## Fwd: Gilman st parking spots

**Christopher Branch** <cbranch@portlandmaine.gov>

Tue, Jan 5, 2021 at 9:53 AM

PROFILE: UTILITY CORRIDOR
STA. 0+00 TO STA. 2+68
SCALE: 1"=20" HORIZ.
1"=4" VERT.

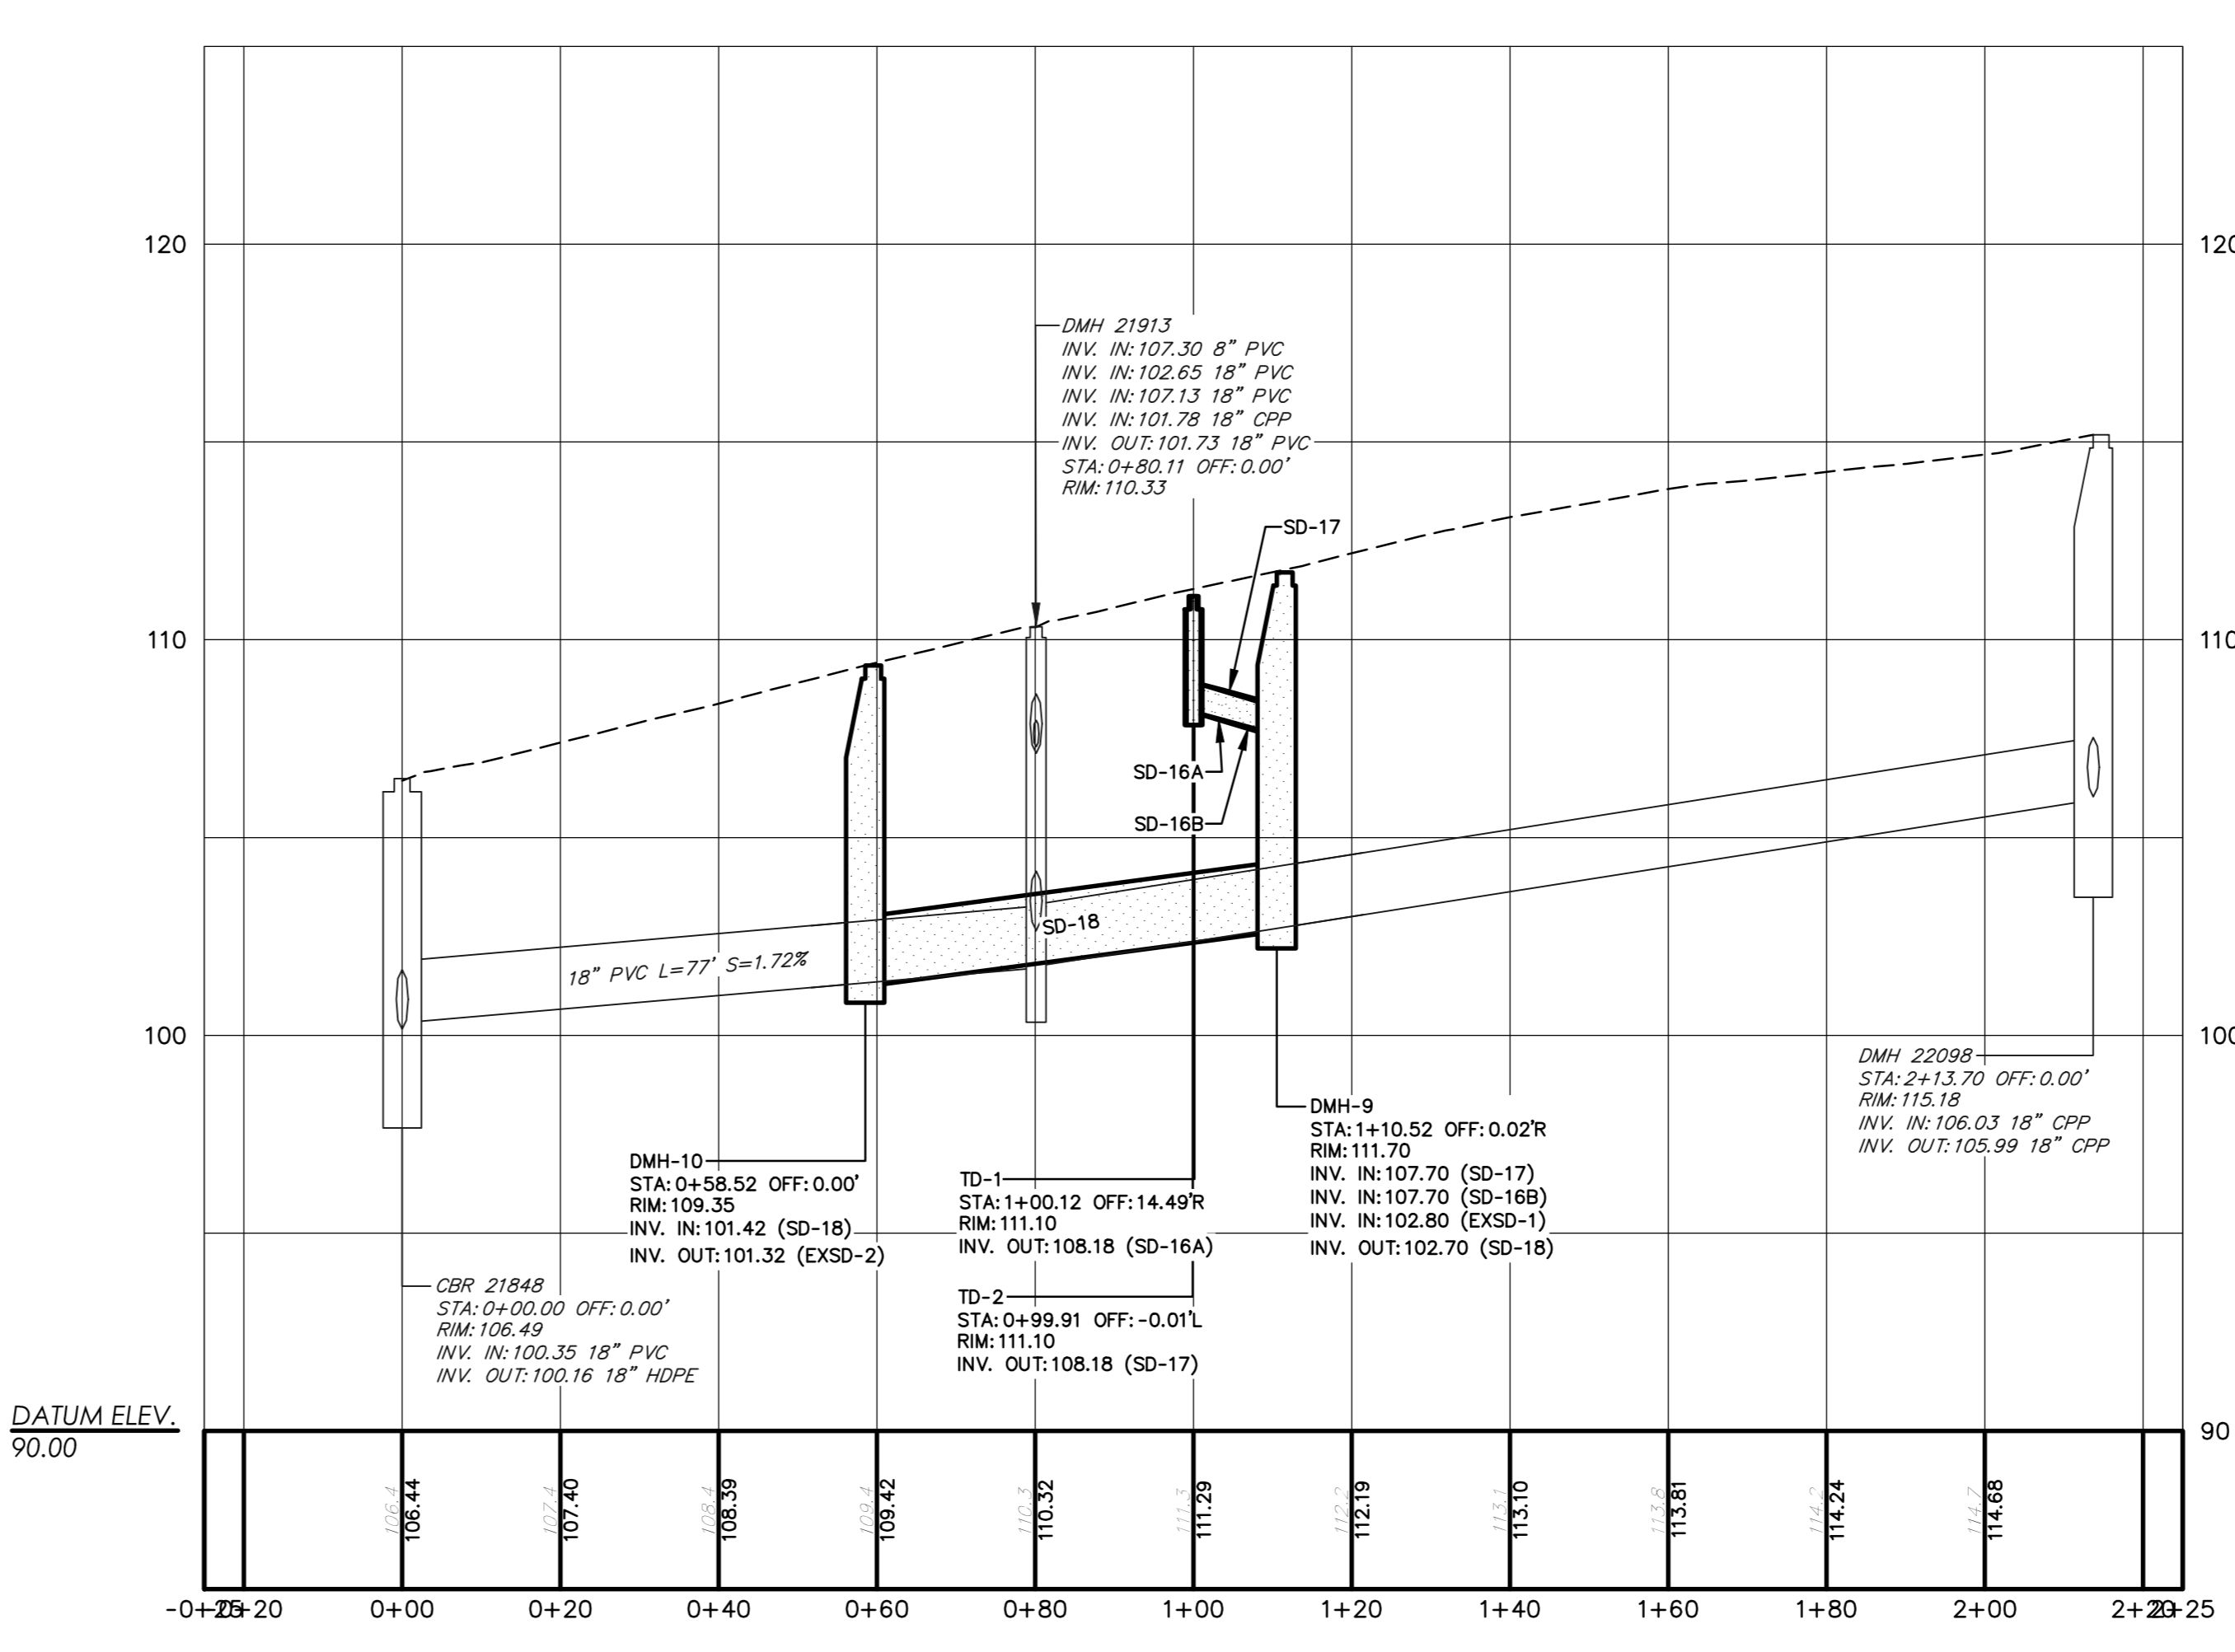
- It appears from the profile they submitted that the tiebacks may extend outside of the City ROW on the side of the street opposite MMC. They show a dimension of 51.7' to the end of the tieback that starts within the ROW, which is 50' wide. This assumes the location of the ROW line on the profile is correct.

- Brad indicated there is an existing storm drain in Gilman it needs to be added to the plan and profile.
- They will need sign offs from all the utilities in the street. The plans show UNITIL, PWD, City Water Resources and there is a duct bank, which I assume belongs to CMP.

- The profile shows the soldier piles and lagging within the City ROW and says they will be removed to a depth 4' below grade. If within the City ROW, it should be lower than 4'.

- I'd like to see profiles for all 4 of the tiebacks on Gilman St.
